Date: 28/10/2025 14:25 (GMT+00:00)
To: louise.bearcroft@kirklees.gov.uk
Subject: Planning Application 2025/44/92737/E

Subject: Concerns Regarding Drainage and Flood Risk – Development at 43 Moor Lane,
Gomersal

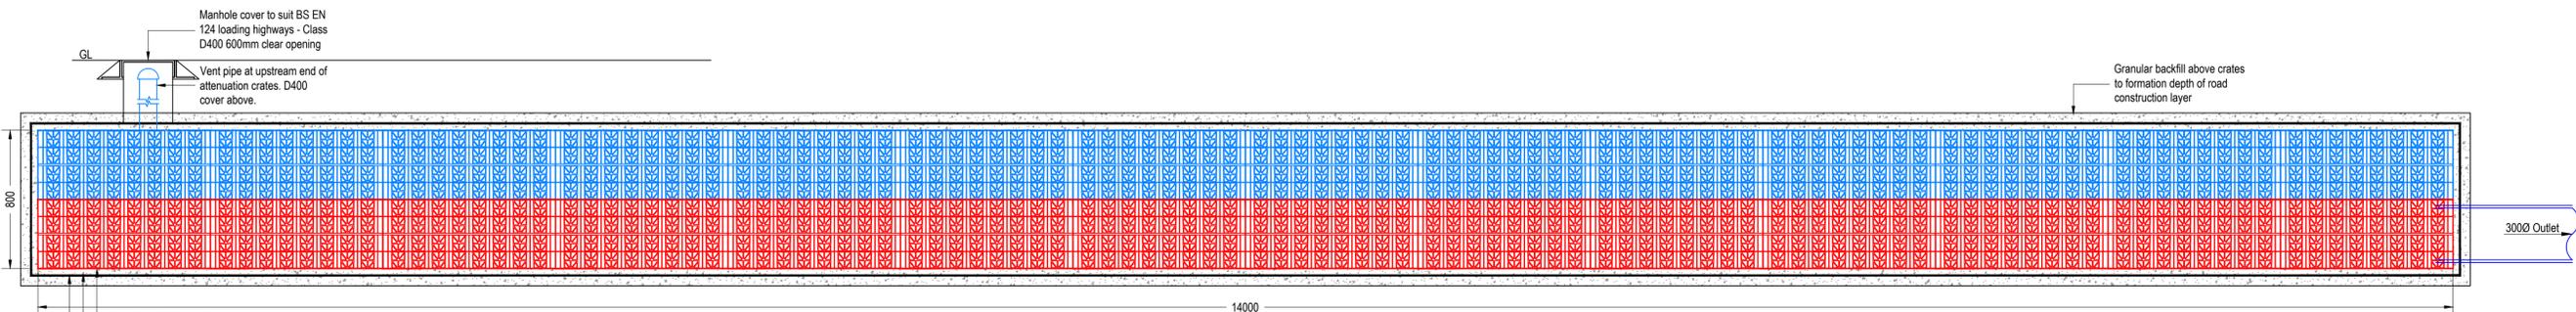
From what I can see, the proposed crate system for surface water drainage appears to be a rather flimsy option, and one that seems highly susceptible to failure. I am also concerned about the decision to combine the surface water and foul water systems. The original plans proposed two separate systems, with foul water being pumped back up the site — a design that appeared to be far more robust and appropriate for this location.

**Private Drainage**

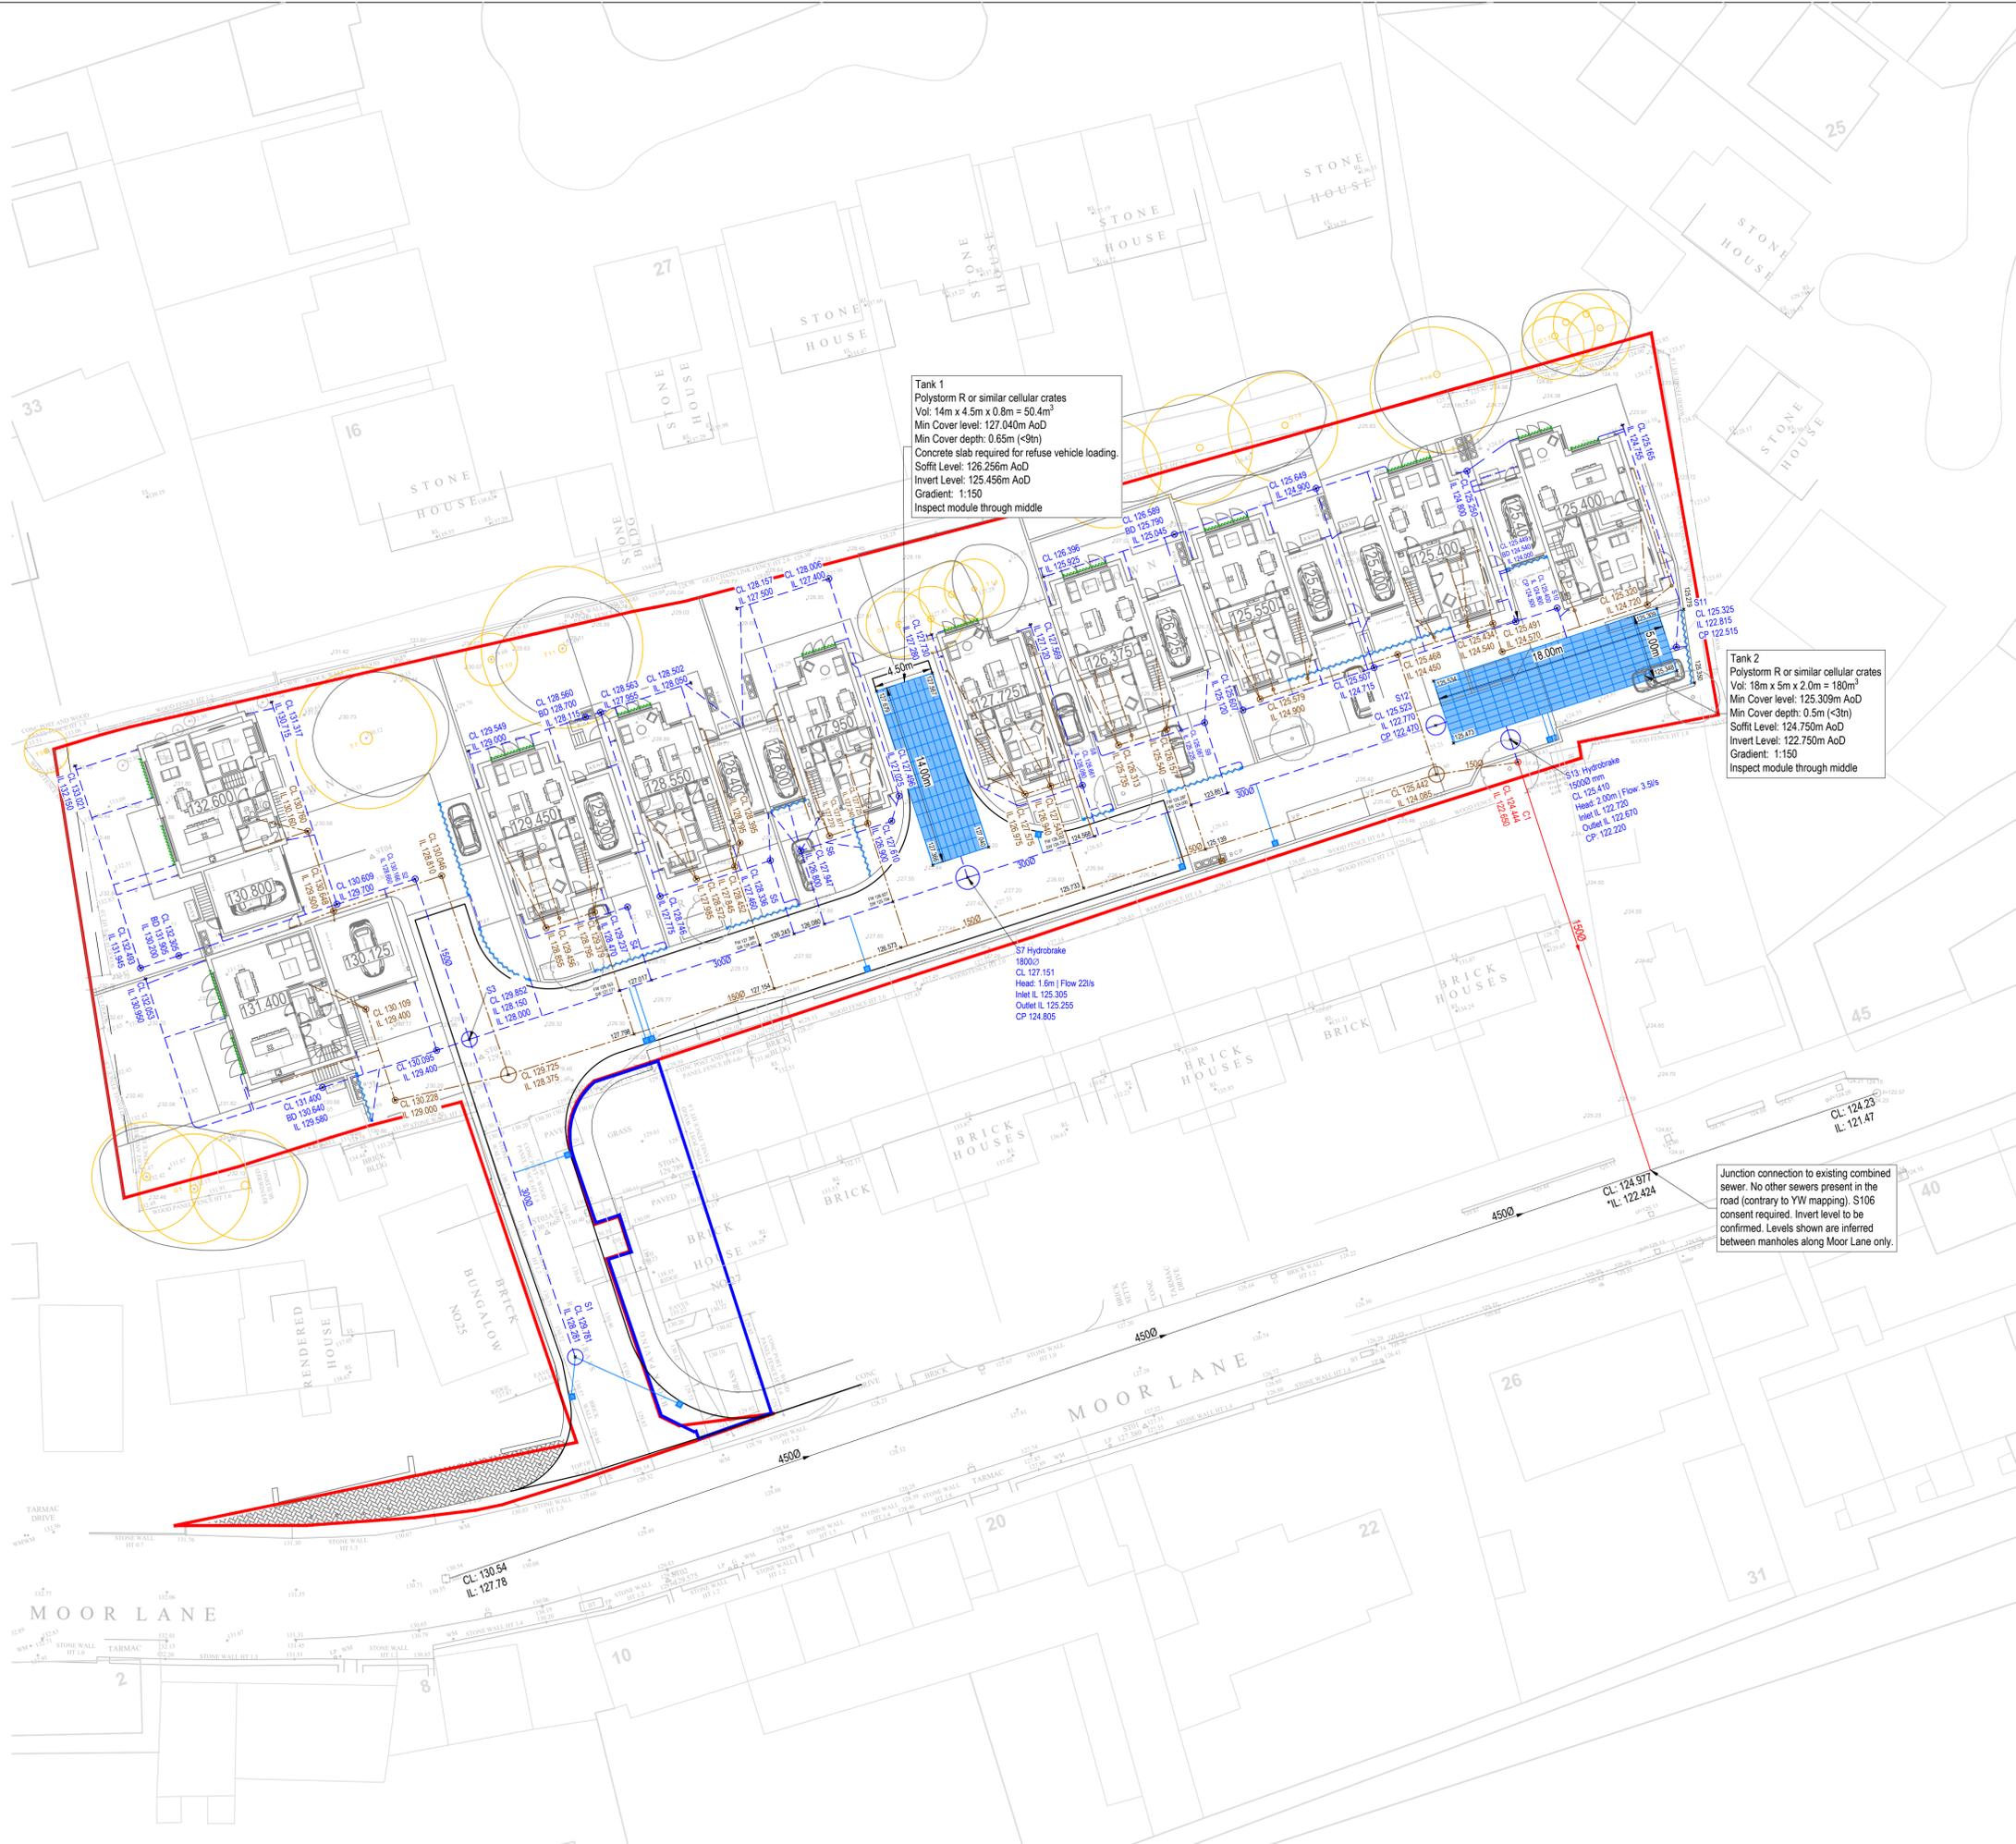
In reviewing the flood plan, it appears that a bund wall is proposed behind our properties, with an exceedance route to the left of our house via point C1 — across the council property's driveway — and an additional route through the garden of 19 Summerbridge. I have attached a screenshot highlighting both of these proposed routes for your reference.

Another issue relates to the new drainage levels and the fall from the proposed site to the existing drains on Moor Lane. The plans suggest the use of a 150mm diameter pipe; however, the garden of 41 Moor Lane already slopes back toward the site, rather than away from it — meaning the gradient would not naturally allow for a gravity-fed system.
